From: Melanie Cork <[REDACTED]>
Sent: 04 November 2021 11:15
To: Kathryn Welch
Cc: Architectural Fuller Associates
Subject: EP/120/21/HH - 9 The Ridings, East Preston, BN16 2TN - revised drawings
Attachments: 01 Extg Plans and Elevs A1.pdf; 02B Prop Plans and Elevs A1.pdf

Further to questions raised by East Preston Parish Council, our client Mr Rush, has reconsidered the proposal to render the brickwork to the existing building and has now decided to retain the brickwork and just render the new elements.

Floor Plans and Elevations -  
Proposed

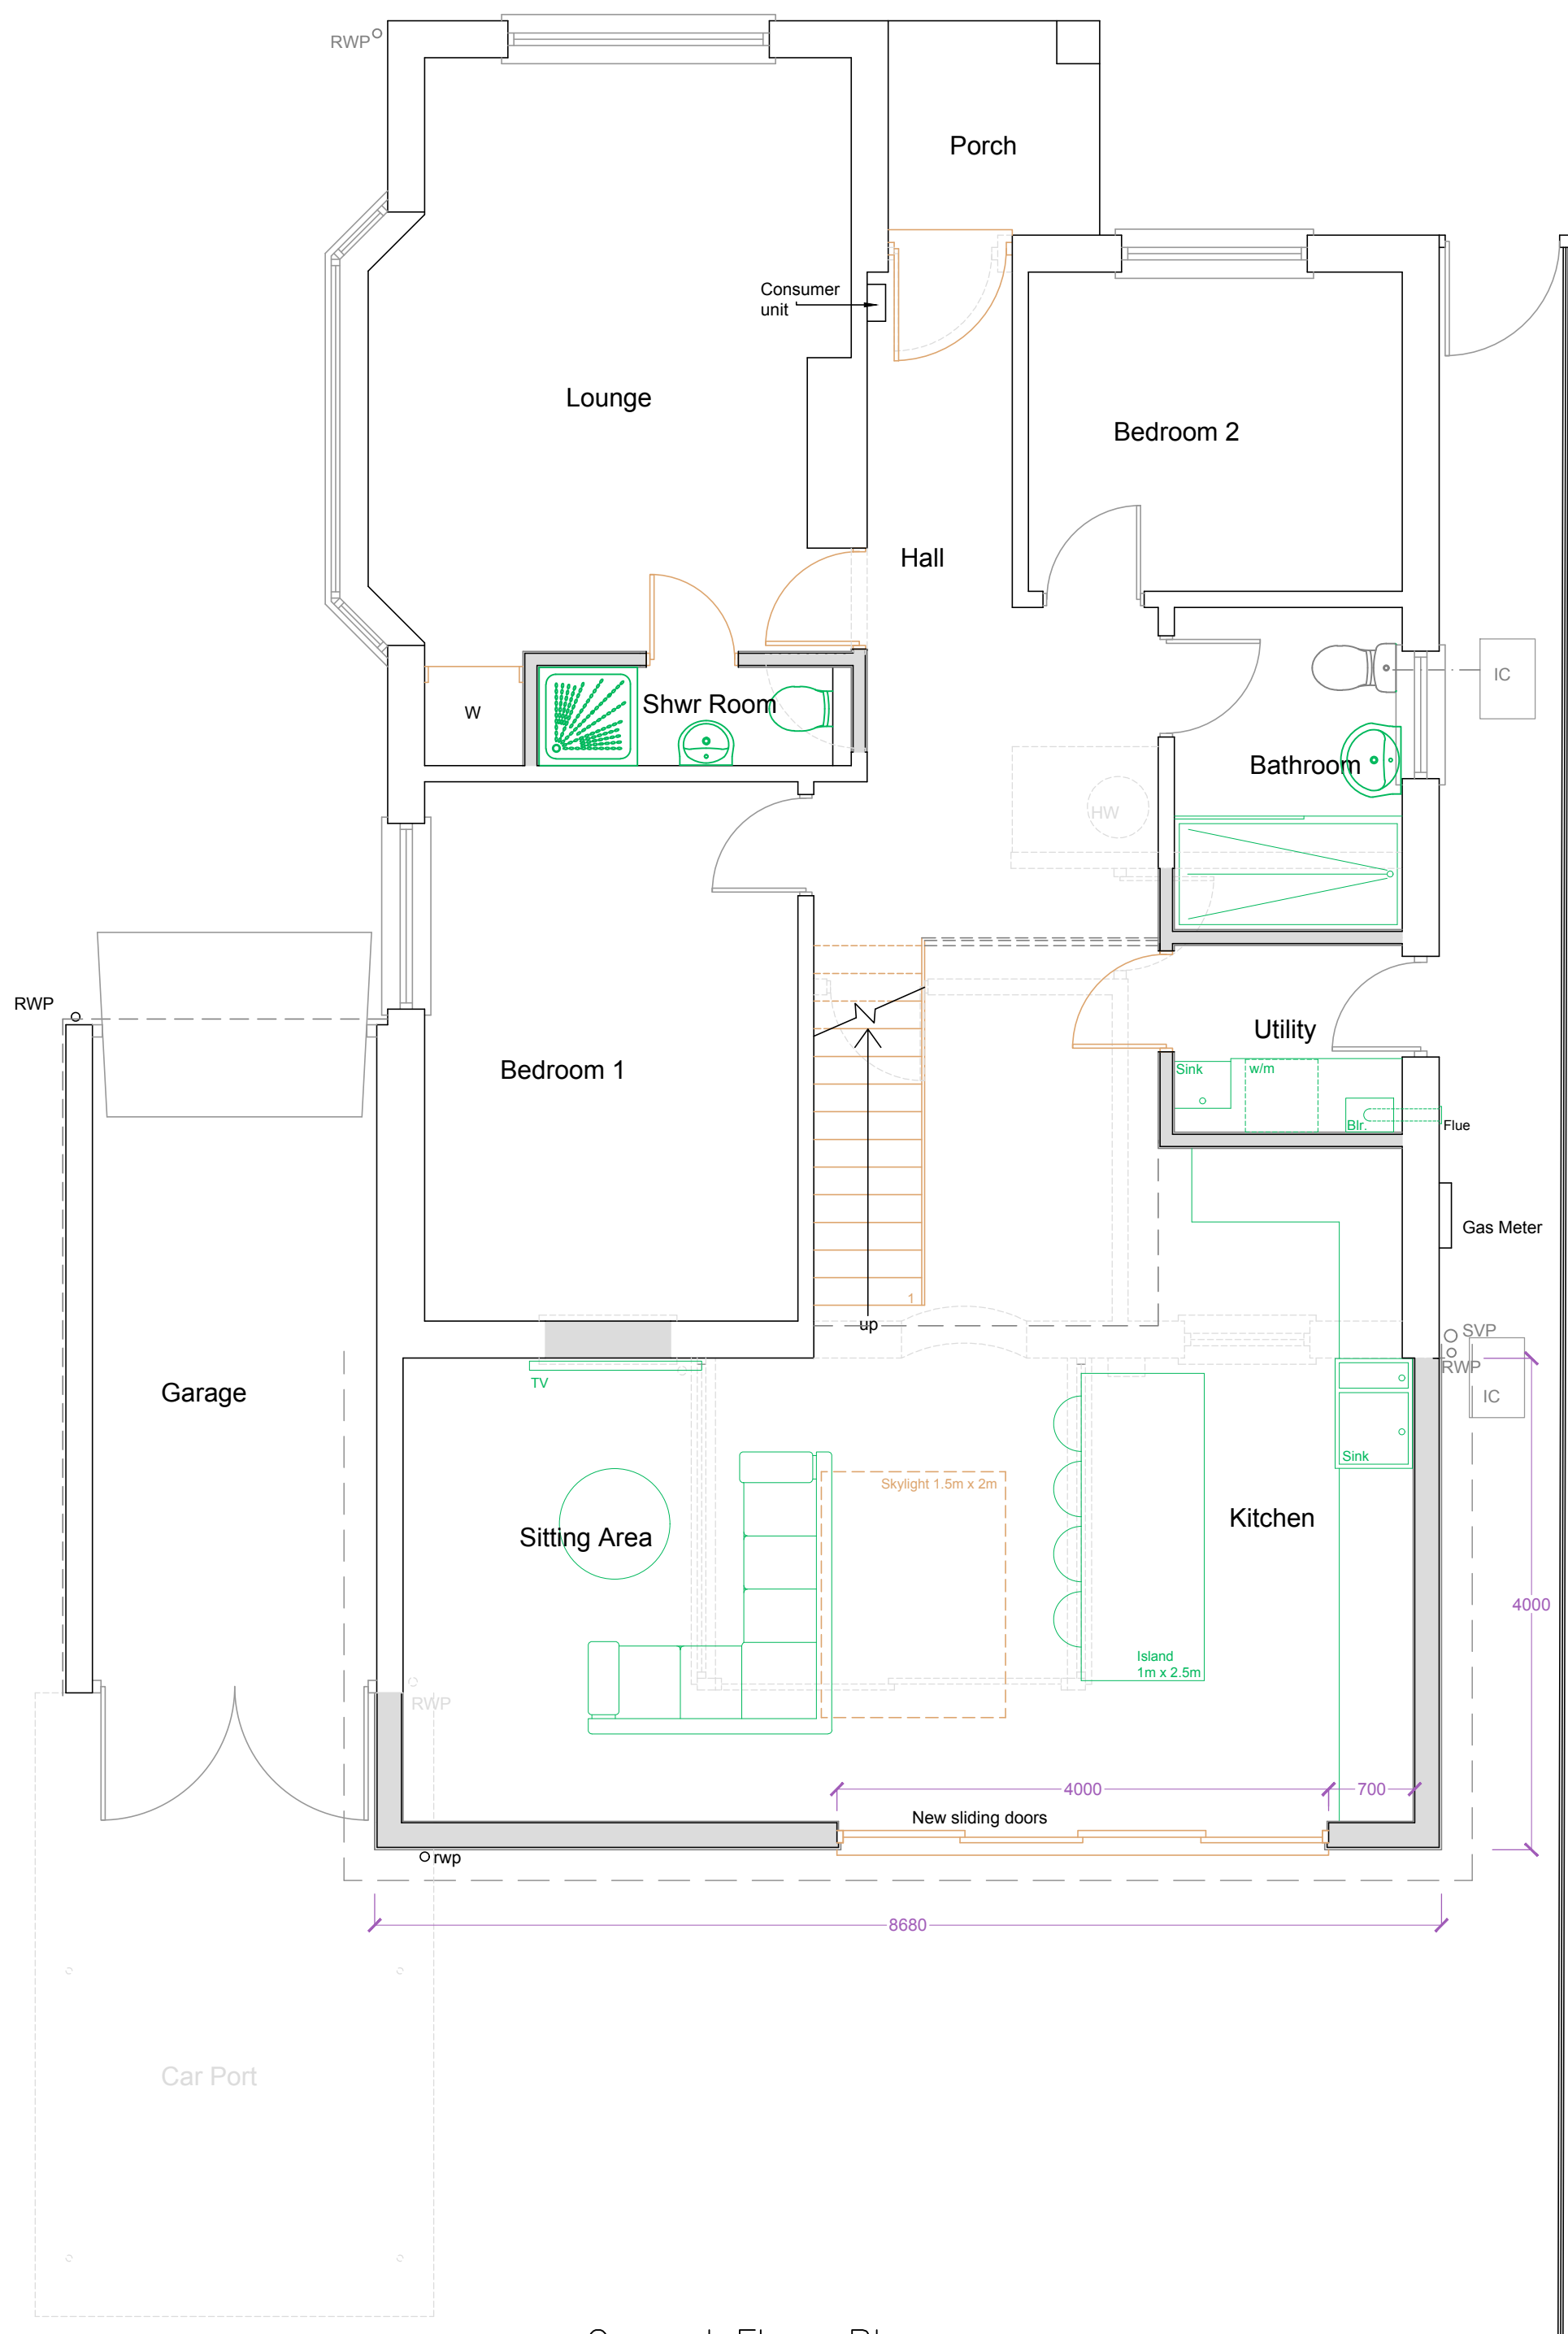
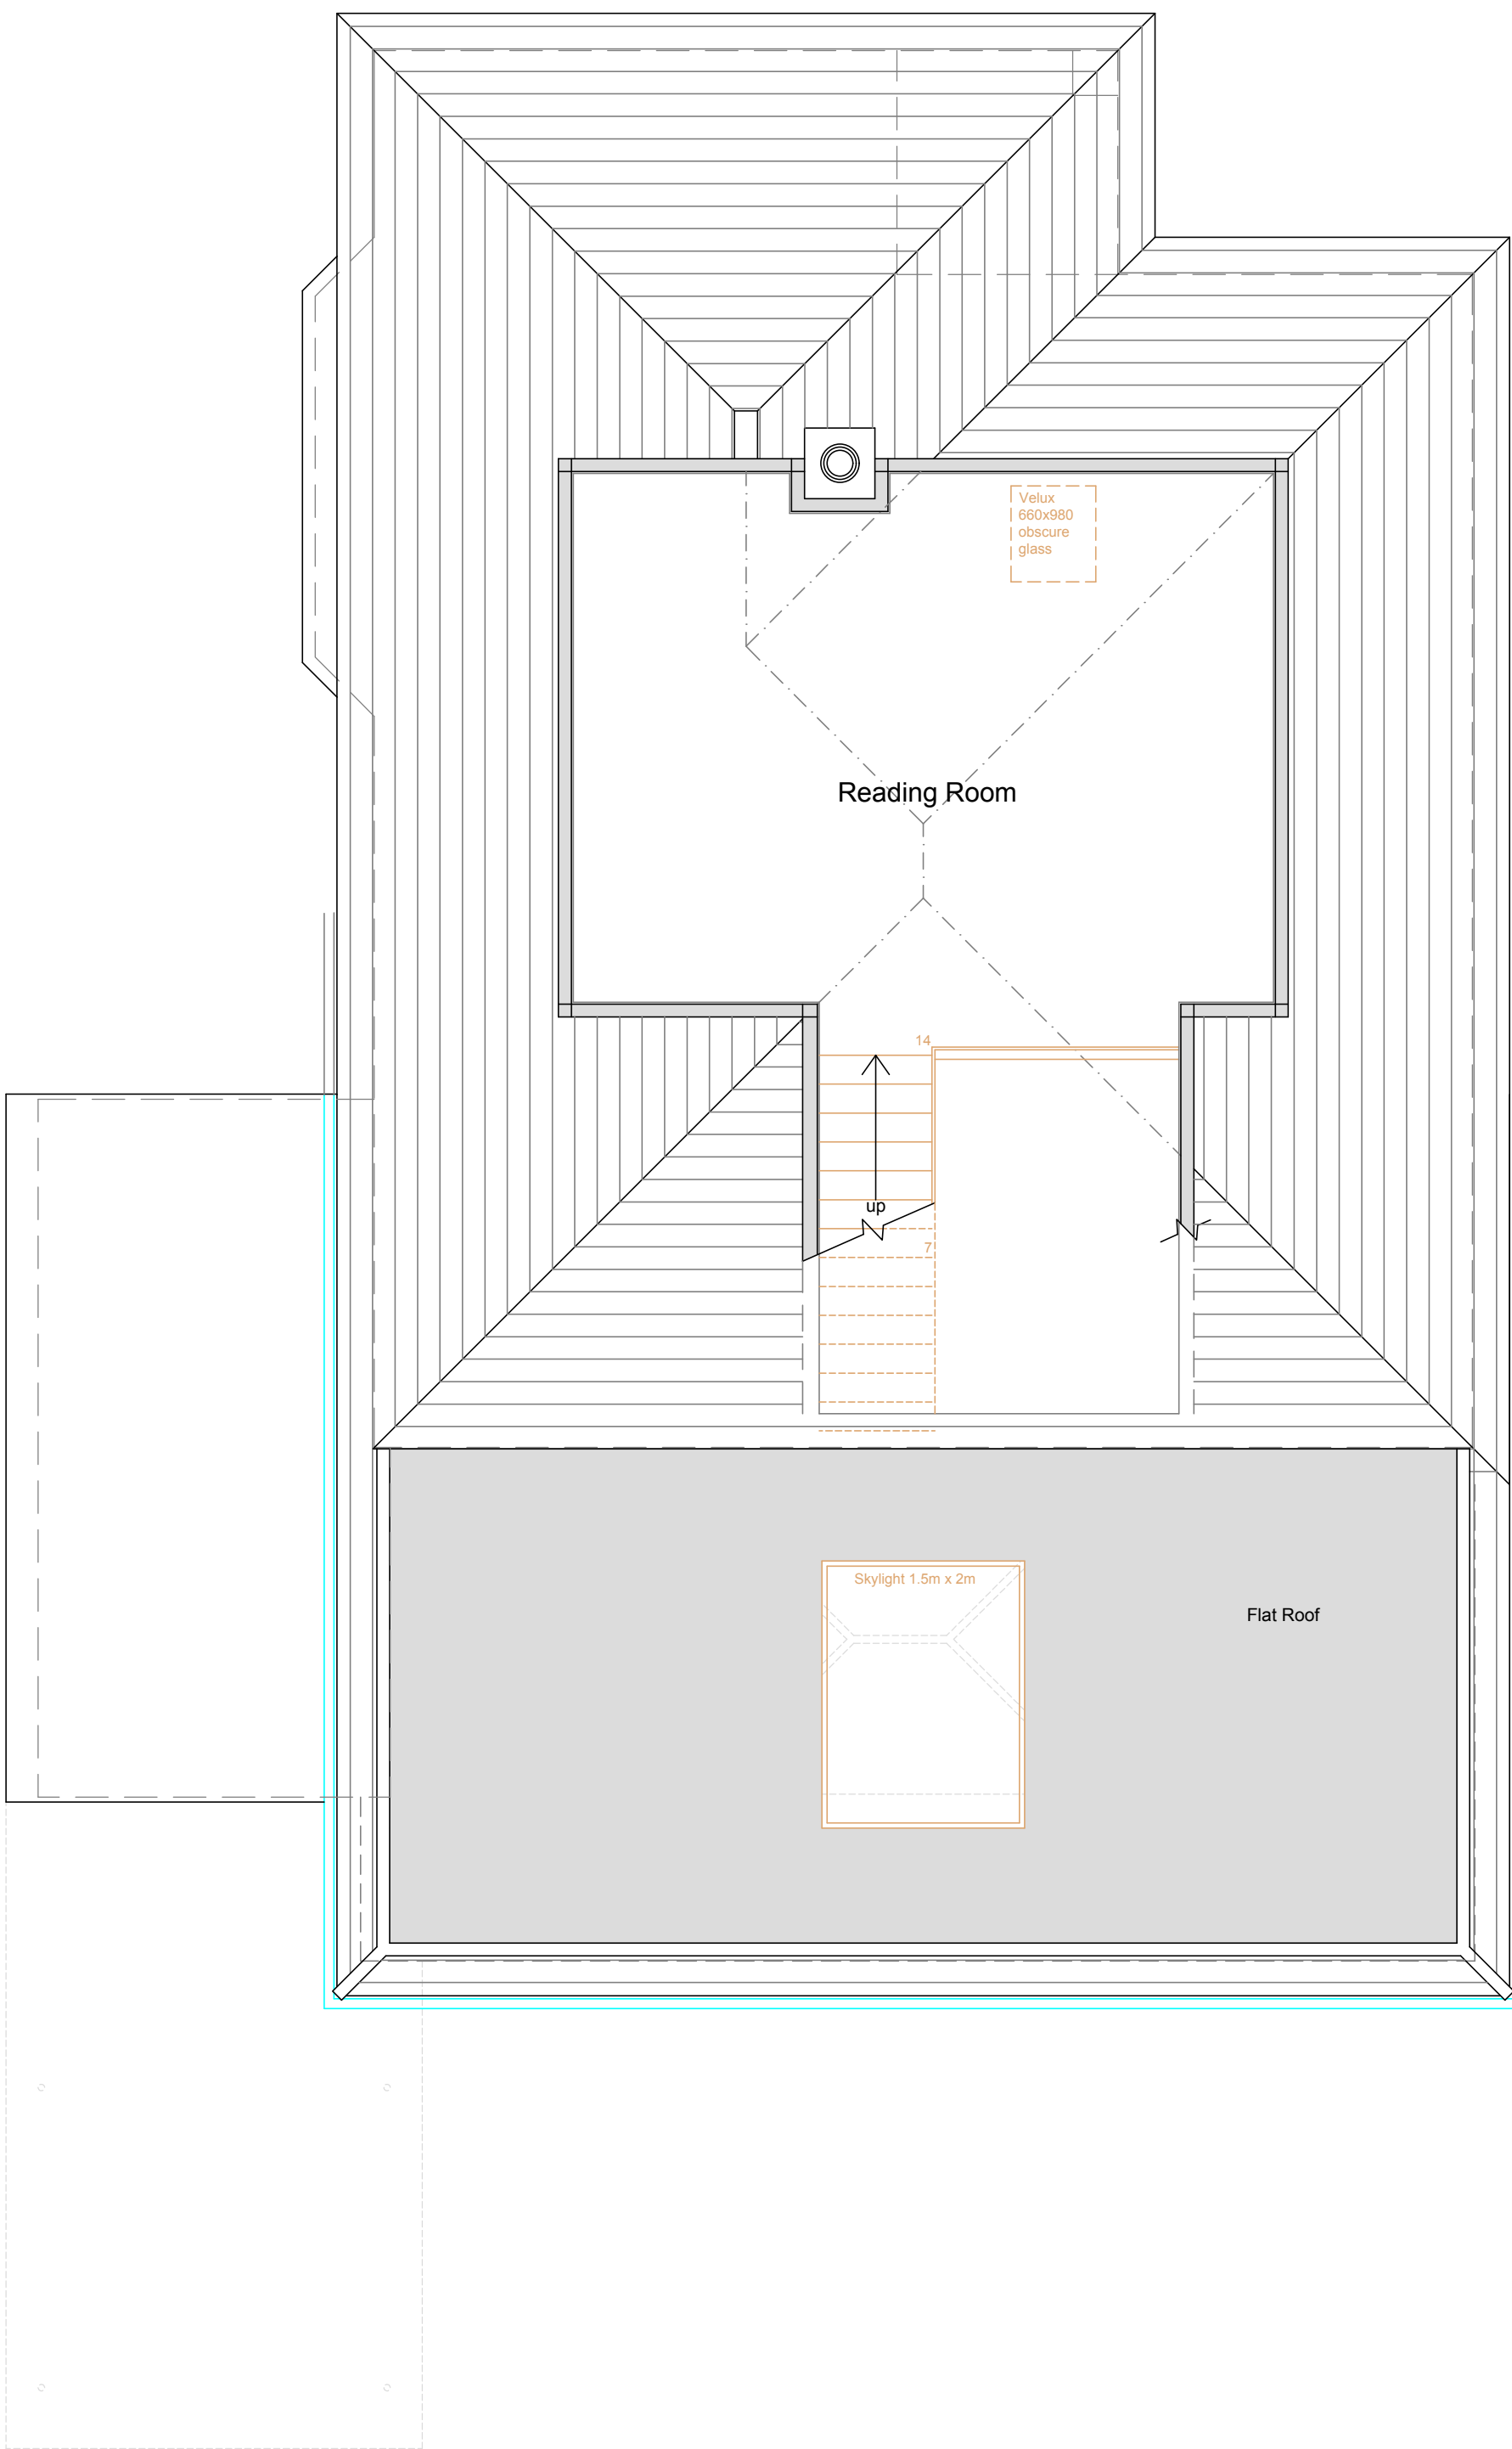
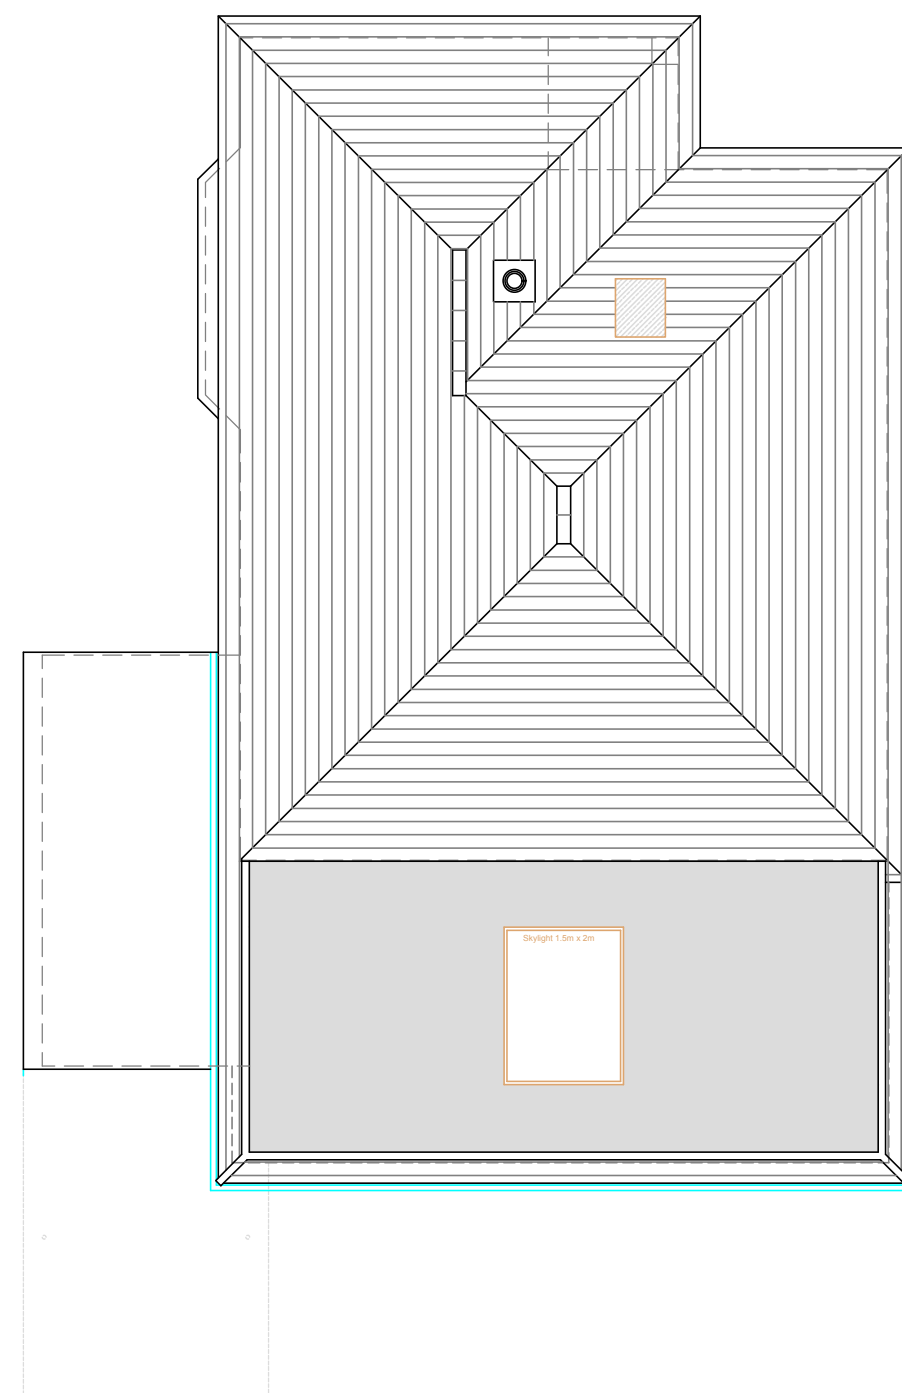
To be clear, the proposal was to render the brickwork to the existing building. However, we have discussed this with our client Mr Rush, who has reconsidered and decided to retain the brickwork to the existing building and just render the new elements.

Please find attached our drawings amended to reflect this. Can you please therefore substitute these for the drawings previously submitted to you.

Please find attached an updated Plans and Elevations drawing which reflects this, which we will sent to Arun DC to substitute with the current proposed drawing.
